Application Ref: H03-0681-21

Proposal: **Details of external materials, landscaping and surface water drainage (Conditions 3, 5 & 8 of H03-1153-18)**

Location: **Poplar Farm Estates Ltd, Main Road, Deeping St Nicholas, PE11 3DJ**

ADDITIONAL INFORMATION REQUIRED

Typical Permeable Driveway Detail

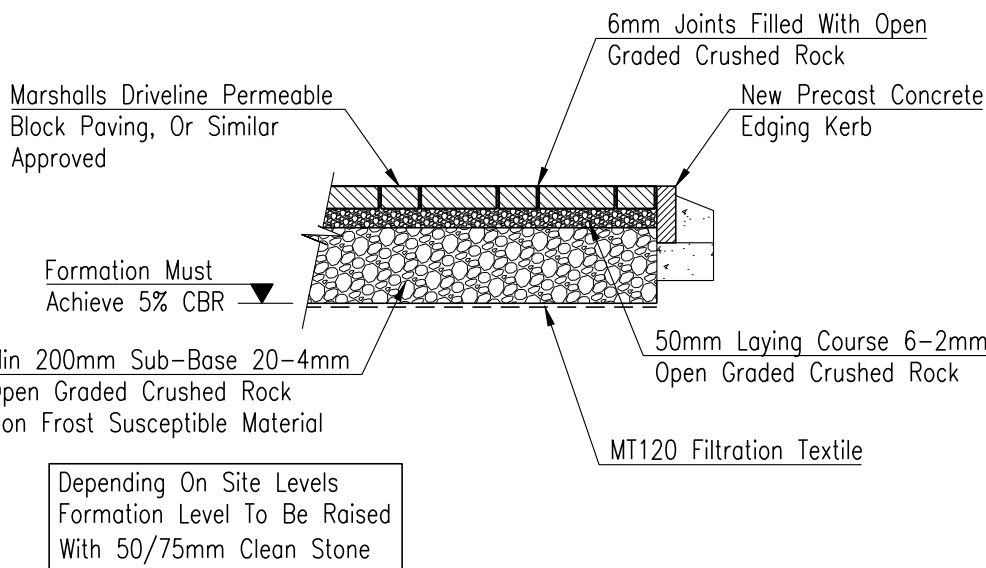
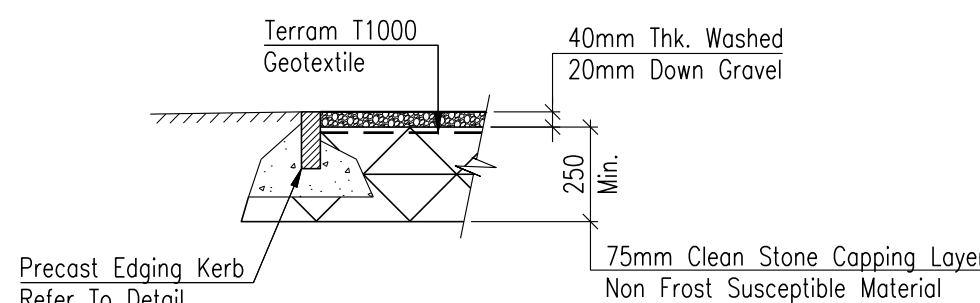
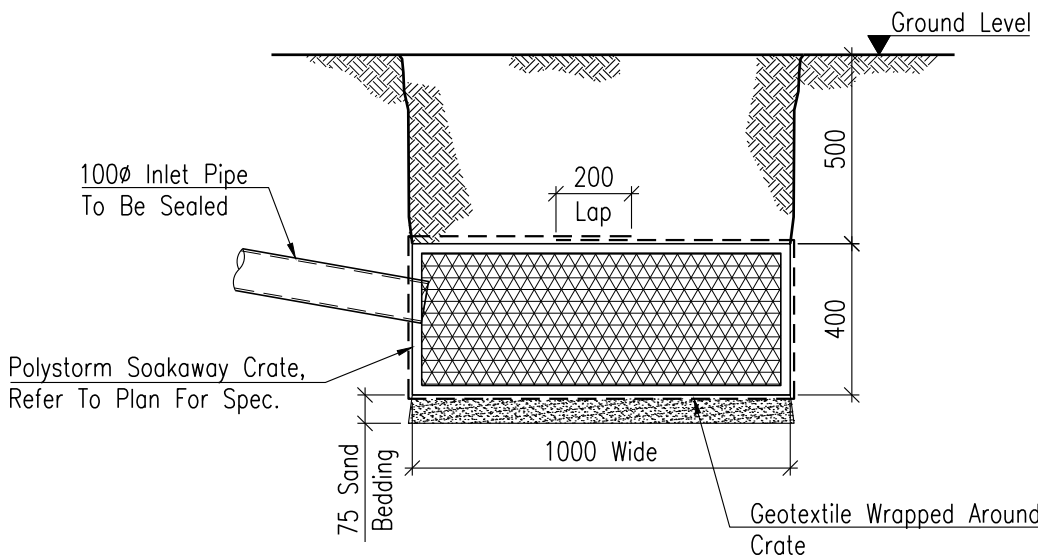
To this end, it is recommended that the Applicants or their Drainage Consultant be asked to provide evidence that the soils of the Application site have been proven by prescribed testing processes to be suitable to allow infiltration from the proposed permeably paved private roadway and drives, that the thickness of the stone sub-base of the private roadway and drives has been designed to provide the required capacity for the storage of storm water and that the specification of the stone sub-base for the private roadway and drives provides the required voids for the storage of stormwater - the description of 'Open Graded Crushed Rock Non-frost Susceptible Material' does not provide sufficient confidence that the required material would be laid by the appointed contractor.

Please find attached the updated civil engineer drawings with further information on the private roadway and drives sub-base (see ref. 30320-02B) and infiltration tests as requested.
